# **CHATBURN PARISH COUNCIL**

## **Planning Application No. 3/2018/1179 – Land off Ribblesdale View**

Proposed Site Layout

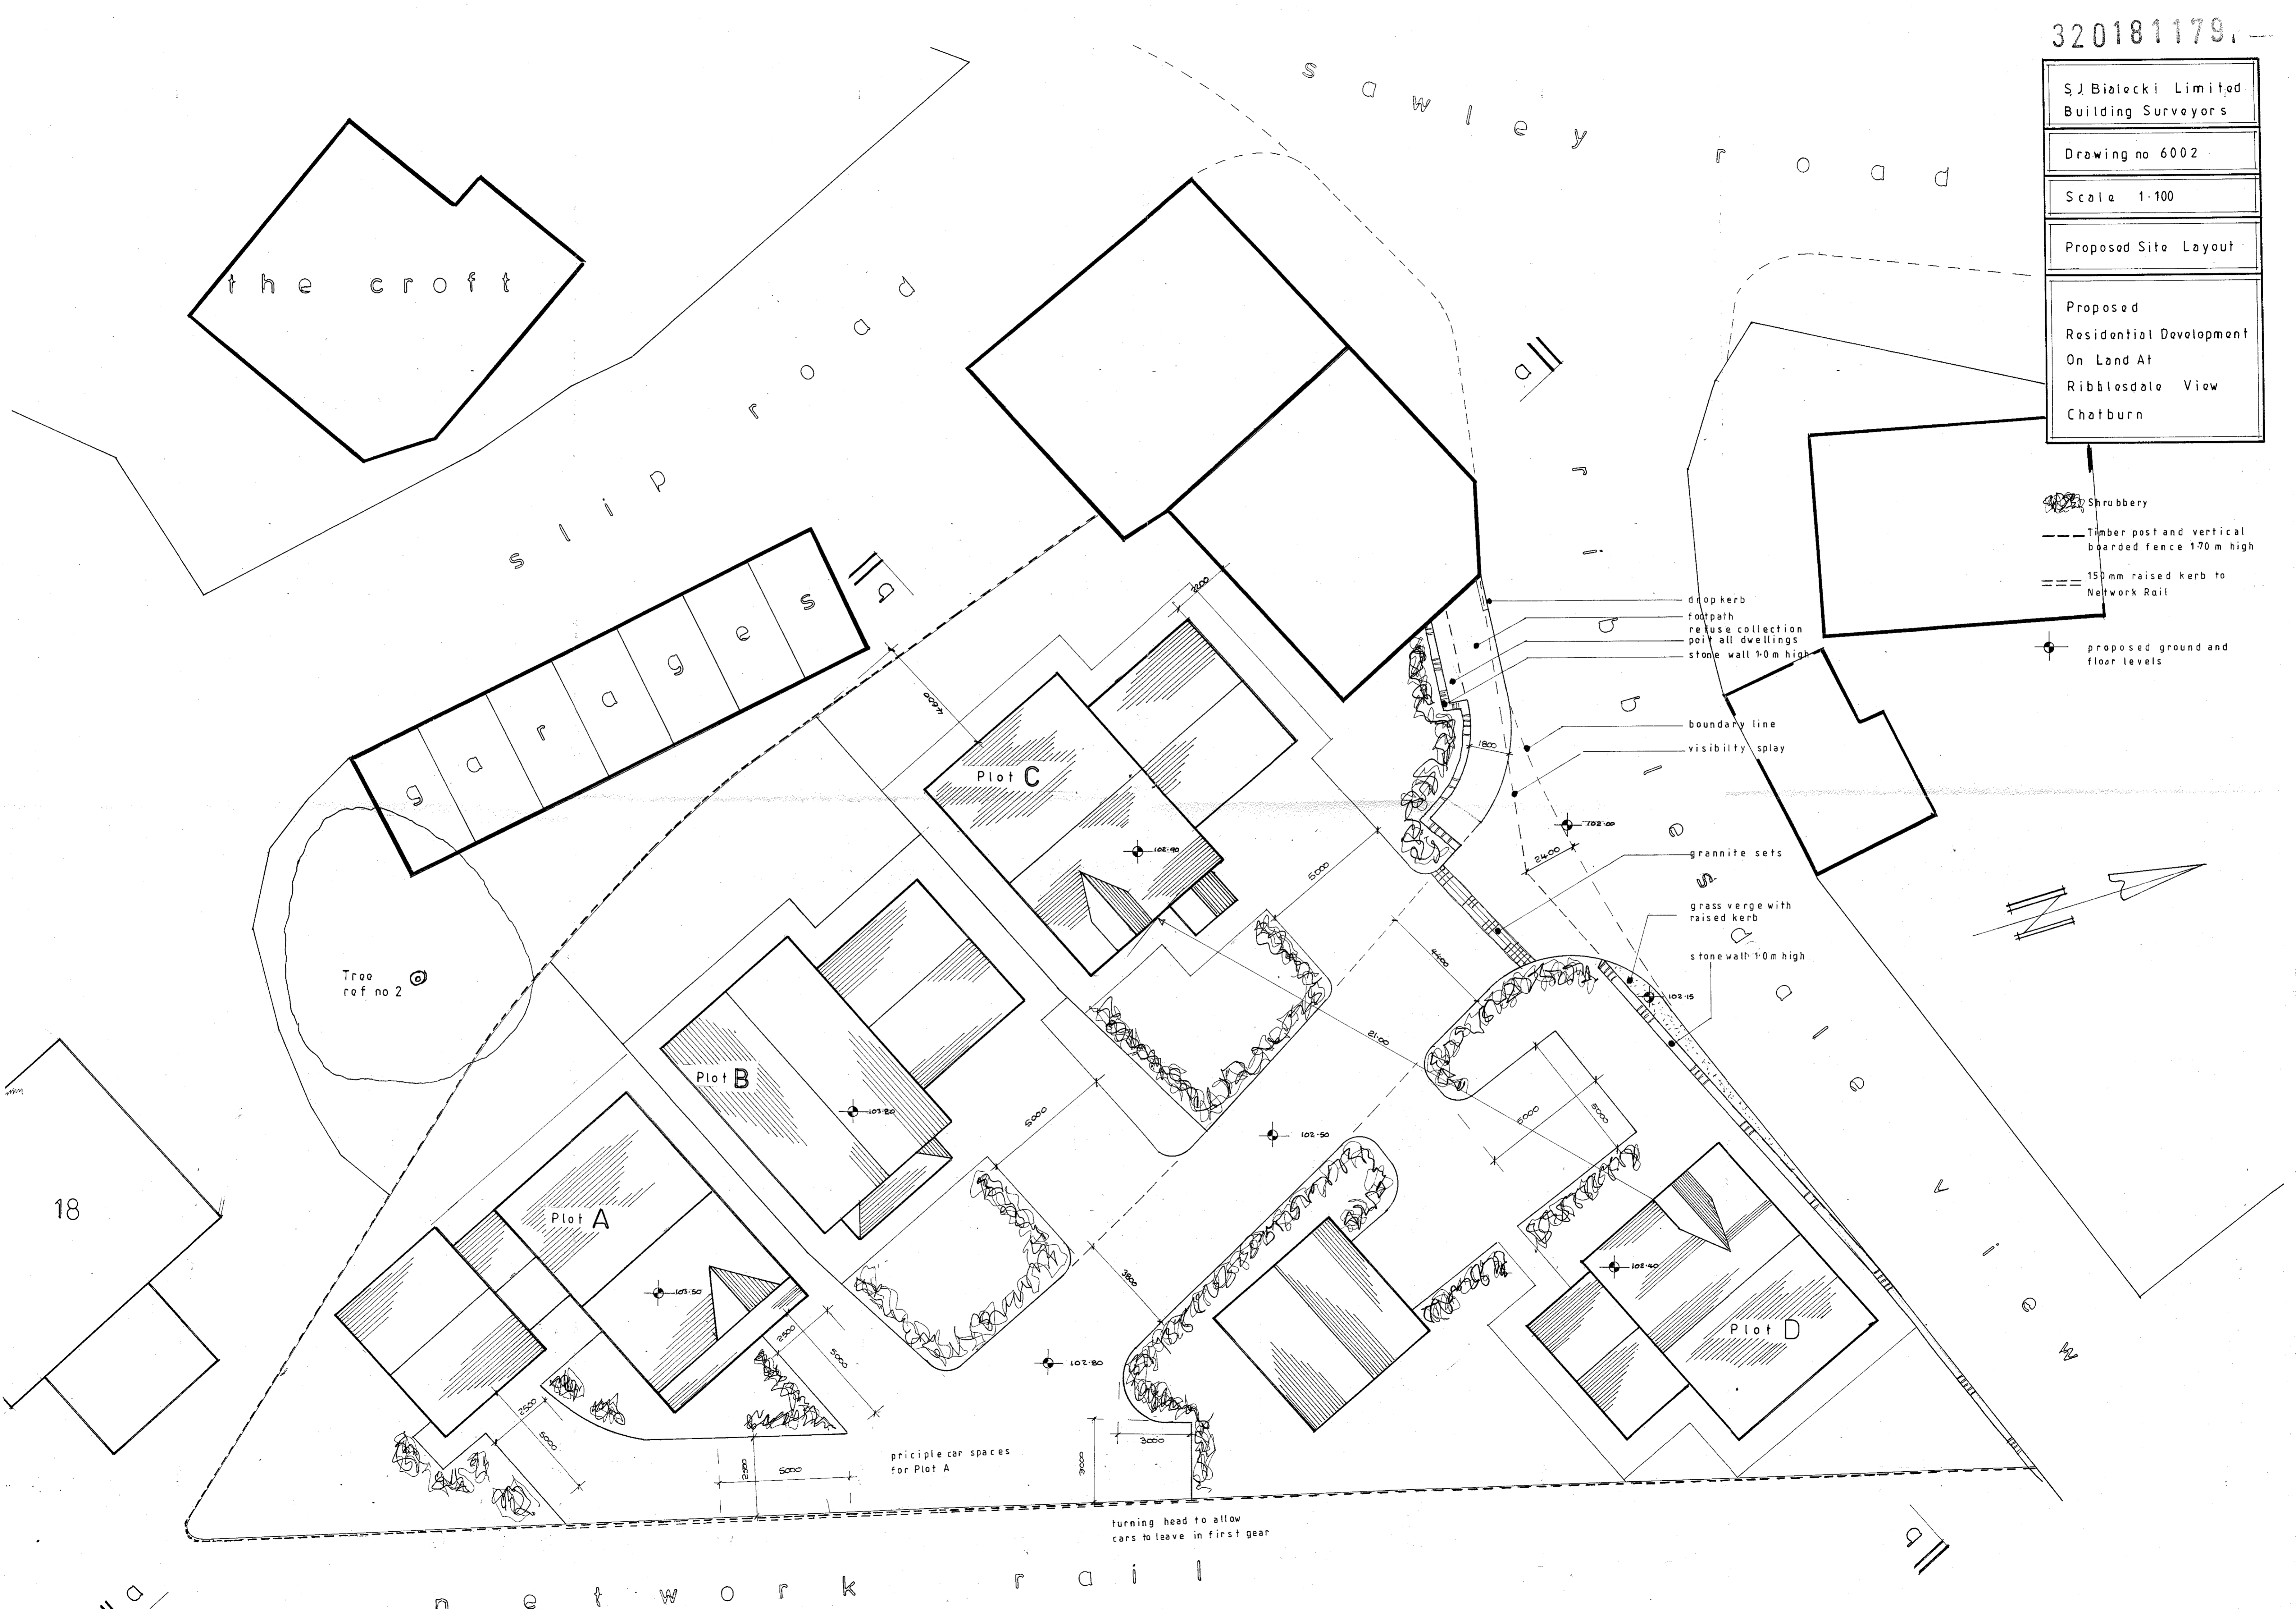
There is no provision for a public footpath as approved in the previous application. It is recommended that the 1 metre high wall be pushed back to allow for a footpath which is essential for pedestrians and particularly for children using Ribblesdale View to walk to Chatburn School.
